**Addendum No. 1**

RE: Contract # C204712

**Guilford County (B-5717)**

BRIDGES #109 AND #121 OVER SOUTH BUFFALO CREEK ON SR-4240 (EAST GATE CITY BLVD) IN GREENSBORO

USER: gregory.cole
DN: cn=Gregory Cole, ou=Engineering, o=AECOM, c=US
DRAWING NO: B-5717-S1-02
PROJECT NO: B-5717
SHEET NO: S1-02

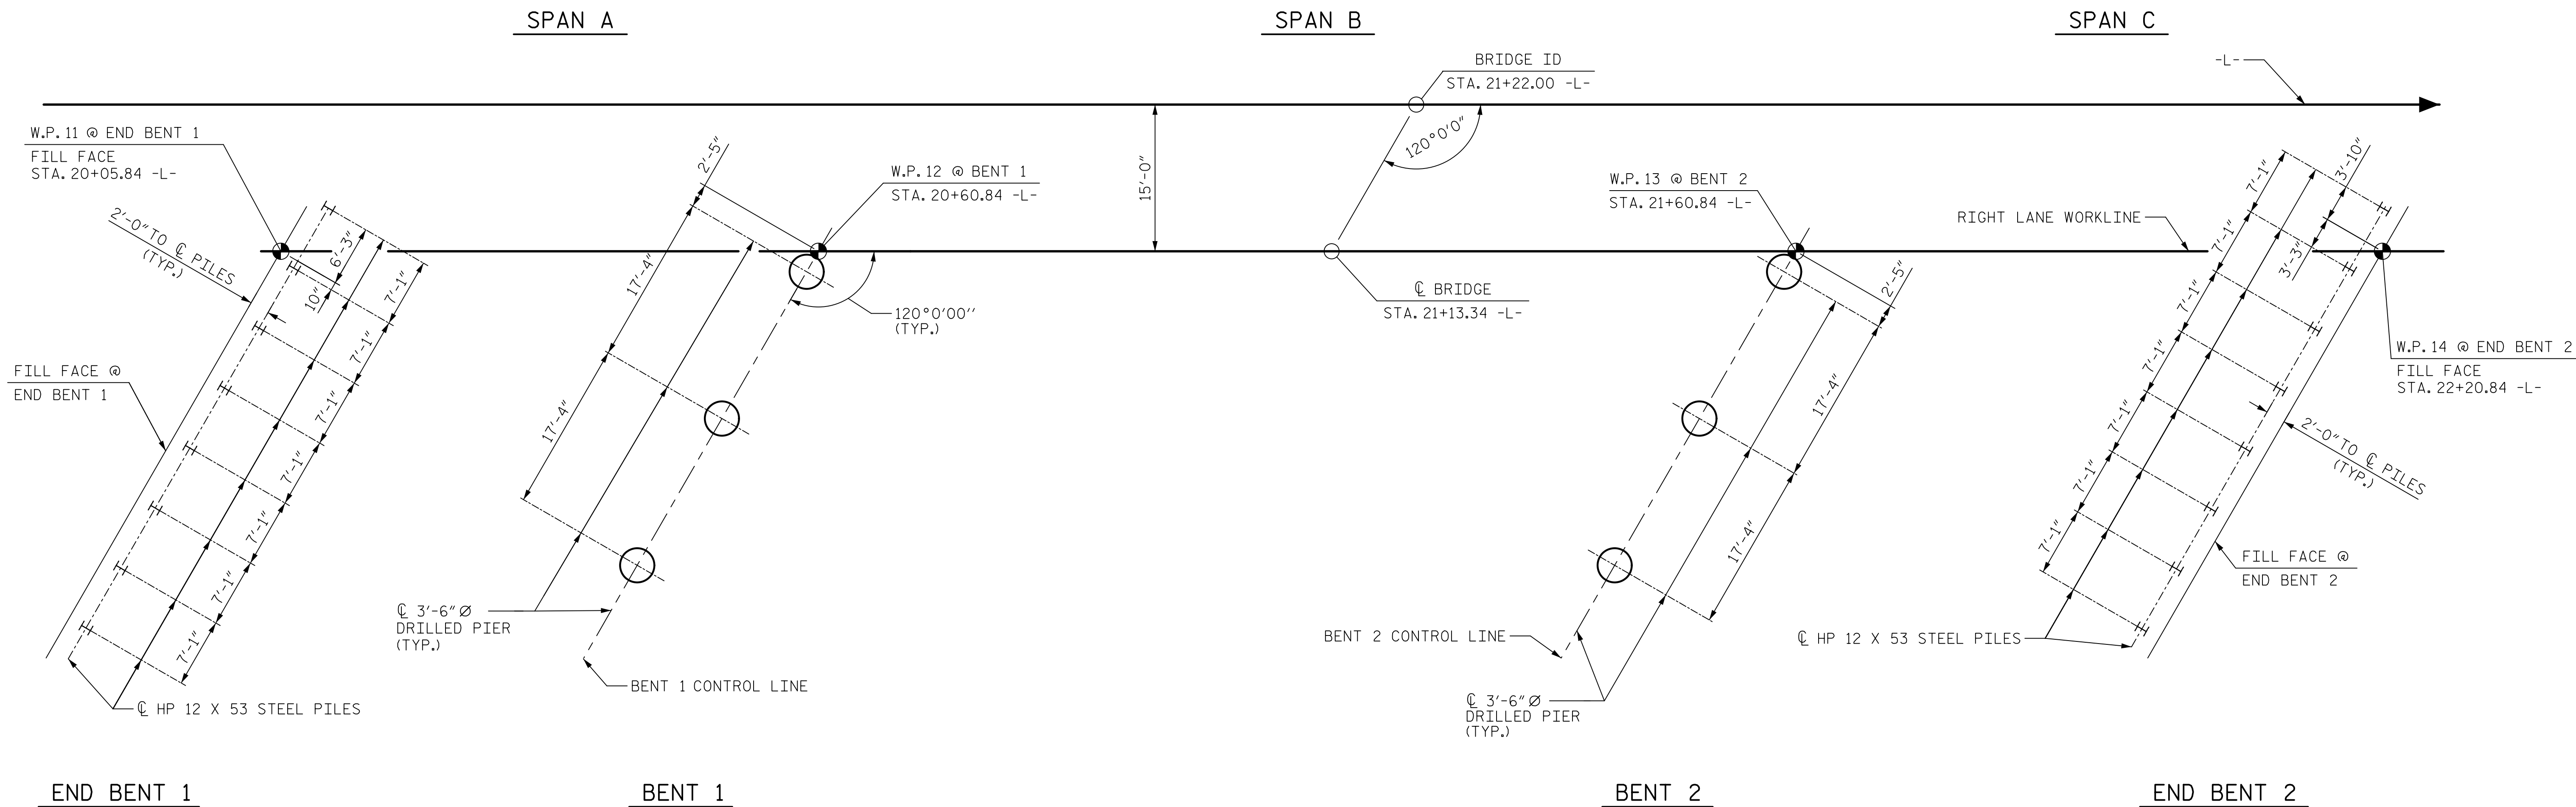
Sheet No.	Revision
S1-02	Foundation Notes #4 and #5 deleted. Special Foundation note #2 revised
S1-03	Predrilling for Piles pay item removed from BOM
S1-28	Predrilling for Piles pay item removed from BOM
S1-35	Predrilling for Piles pay item removed from BOM
S2-02	Foundation Notes #4 and #5 deleted. Special Foundation note #2 revised
S2-03	Predrilling for Piles pay item removed from BOM
S2-28	Predrilling for Piles pay item removed from BOM
S2-35	Predrilling for Piles pay item removed from BOM
